**Our Case Number:** ACP-323950-25

**Re:** Flood Relief Works at Graiguenamanagh, Co. Kilkenny & Tinnahinch, Co. Carlow  
Graiguenamanagh, Co. Kilkenny & Tinnahinch, Co. Carlow

**Uisce Éireann's Ref:** PN25000035363

**Development Description:** Flood Relief Works at Graiguenamanagh, Co. Kilkenny & Tinnahinch, Co. Carlow

010 LANDSCAPE PLAN - AREA 5 & AREA 6

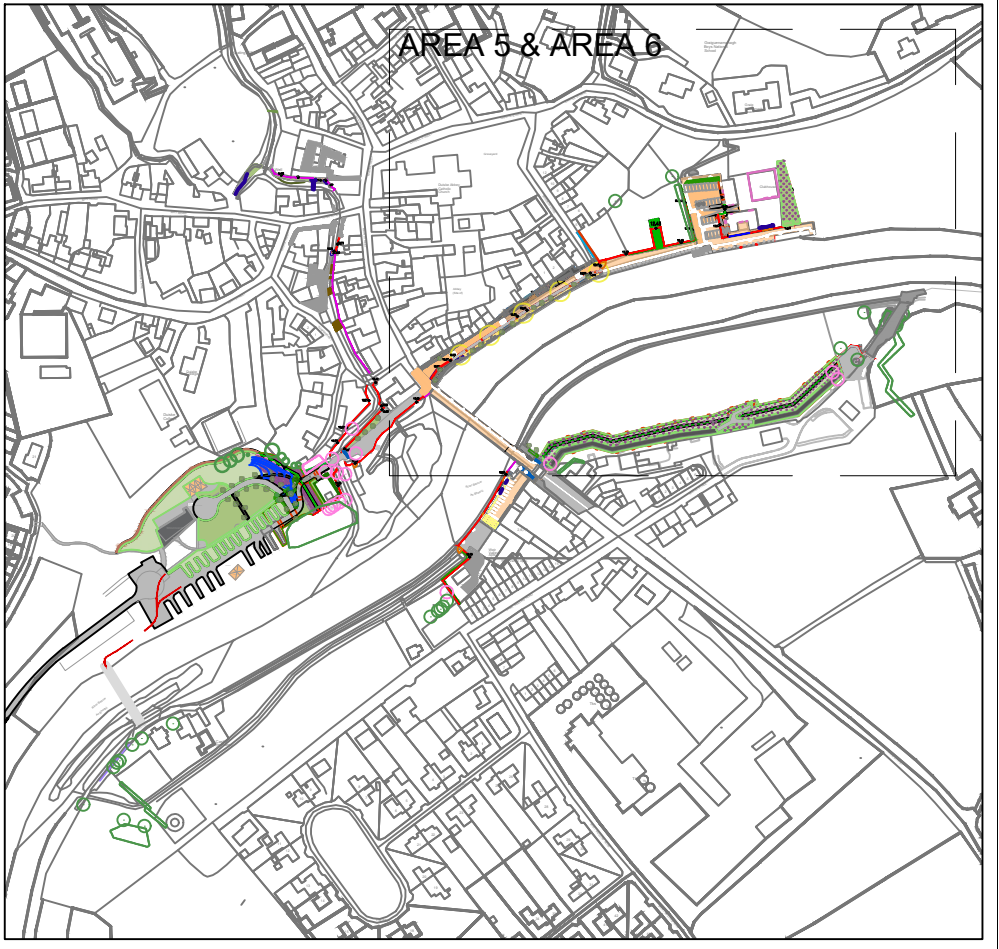
- Area 5 (Boat Club) will require a non-return valve of the foul sewer to be fitted crossing the flood defence line.
- Area 6 (Graiguenamanagh Quay) will result in the removal of the underground telecommunications cables and the diversion of foul rising main from pumping station to the dry side of the wall.
- Area 7 (The Dock) will require the flood defence to be built over the existing foul sewer clashing with wall alignment.

- The applicant shall enter into an agreement to divert assets where required by Uisce Éireann and adhere to the standards and conditions set out in that agreement.
- The applicant shall make provision for an emergency overflow pipe from Uisce Éireann's in situ Wastewater Pumping Station and agree the design for this with Uisce Éireann.
